WEST SUSSEX COUNTY COUNCIL CONSULTATION

TO:	Arun District Council FAO: Hebe Smith
FROM:	WSCC – Highways Authority
DATE:	2 April 2026
LOCATION:	Land West of 26 Greystone Avenue Bersted PO21 5EA
SUBJECT:	BE/18/26/PL Erection of 1 No detached four-bedroom dwelling (self build) with associated car parking, bike store and landscaping. This application is in CIL Zone 4 and is CIL Liable as a new dwelling.
DATE OF SITE VISIT:	n/a
RECOMMENDATION:	Advice

A :: Proposed Ground Floor Plan
01 scale: 1:100

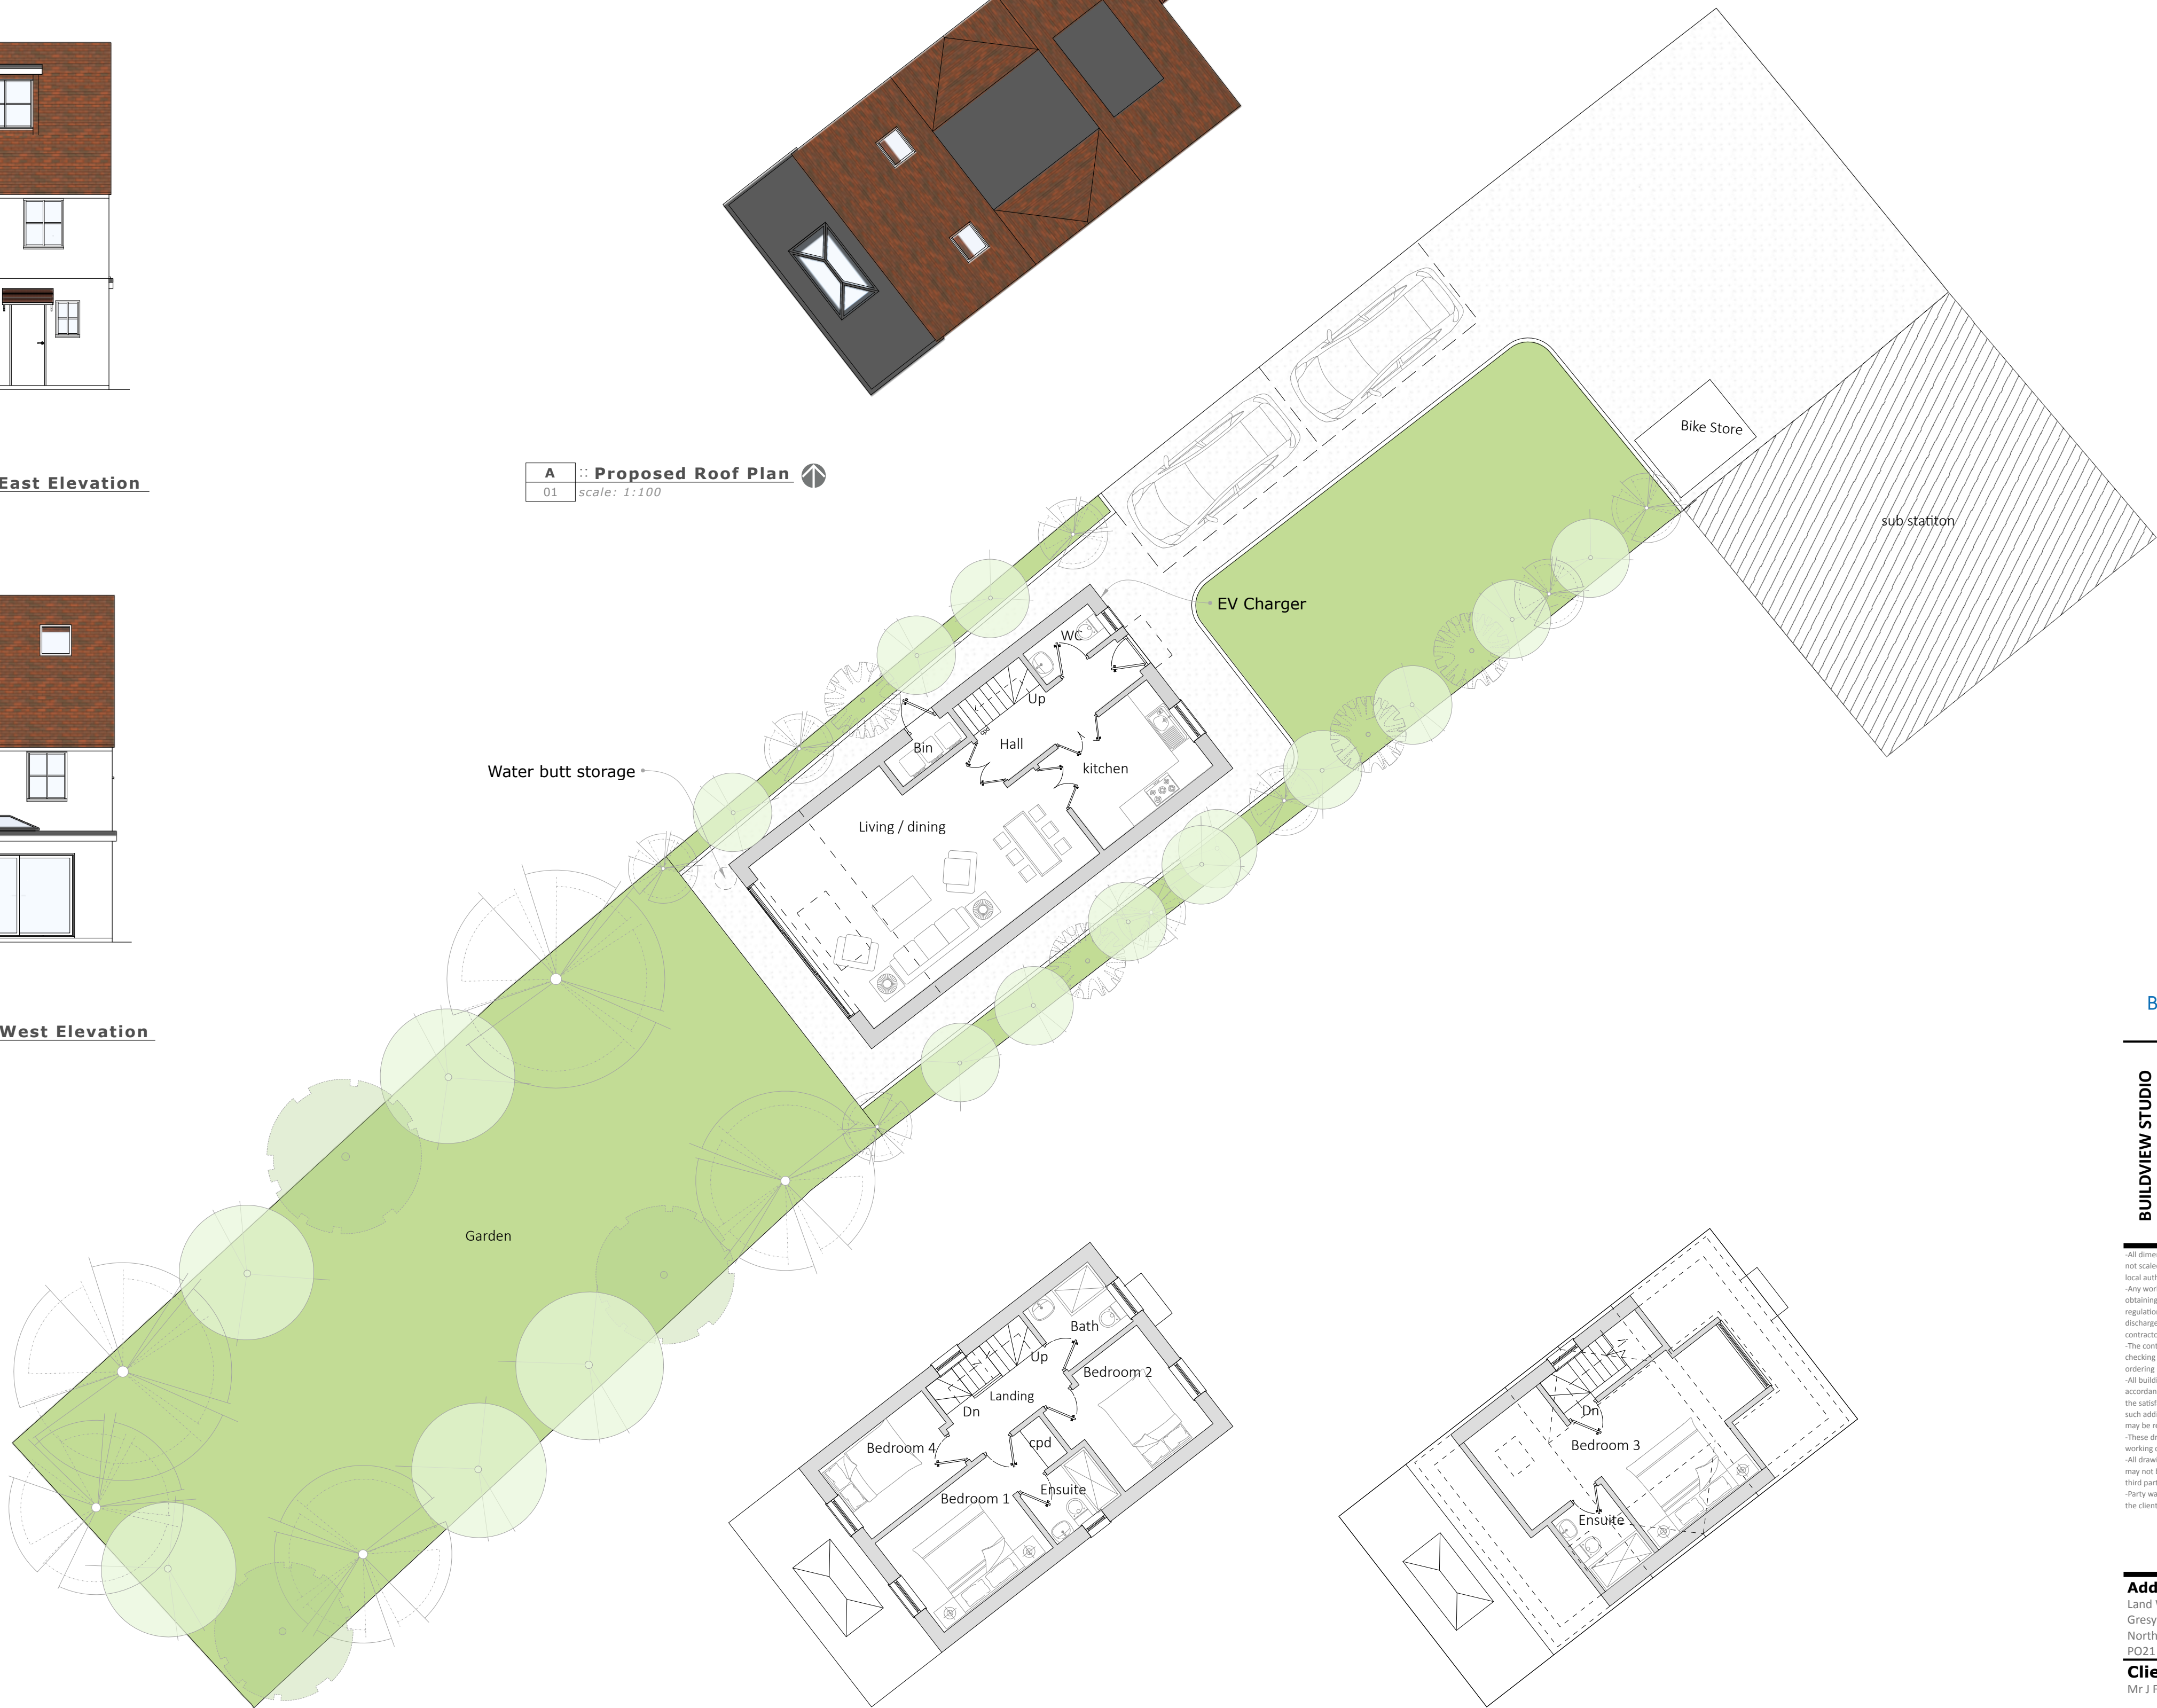
The proposed plans indicate that two parking spaces will be provided on site, in a tandem arrangement. The WSCC car parking demand calculator anticipates that a minimum of three parking spaces would be required for a dwelling of this size and location. The applicant is advised to consider whether a third parking space could be accommodated on site without compromising the ability for vehicles to turn on site to be able to exit onto the public highway in a forward gear.

Car parking space

No part of the development shall be first occupied until the car parking has been constructed in accordance with the approved site plan. These spaces shall thereafter be retained at all times for their designated purpose.
